Opposing to Epping to Thornleigh Third Track Proposal. Application number SSI 5132.

/we object to the Epping to Thornleigh Third Track Proposal and consider that the EIS is inadequate and does not address the full impact of this proposal. It will cause untold damage to the health of residents and to the fabric of the Beecroft Cheltenham Heritage Conservation Area. Do not approve this project, reconsider the alternatives and protect the community.

Figure S.6 Cross-section and elevation - New Cheltenham Station concourse building (see also S.5 for artist's impression)

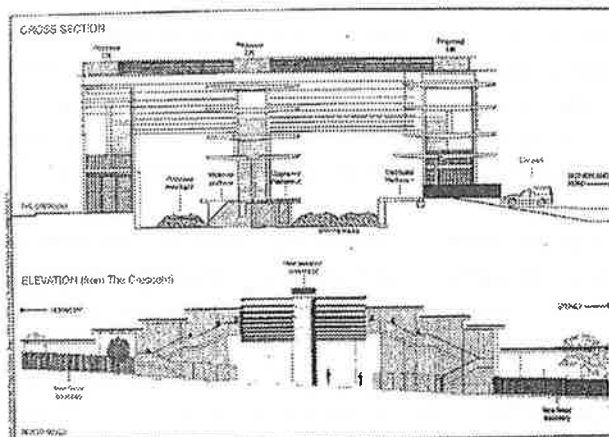
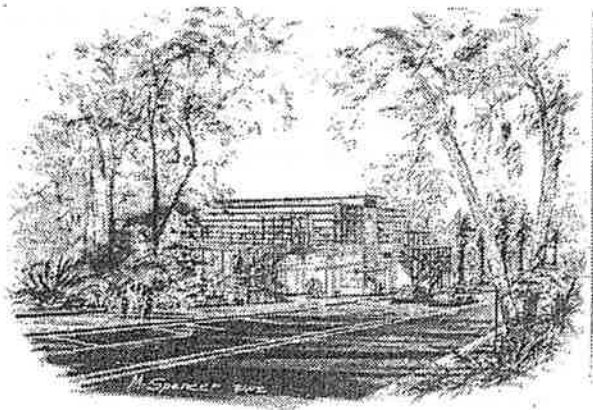
- The proposed redevelopment of Cheltenham Station shows no regard for the HCA. The visual impact of the proposed 13m high glass and steel concourse is totally unacceptable in this HCA.
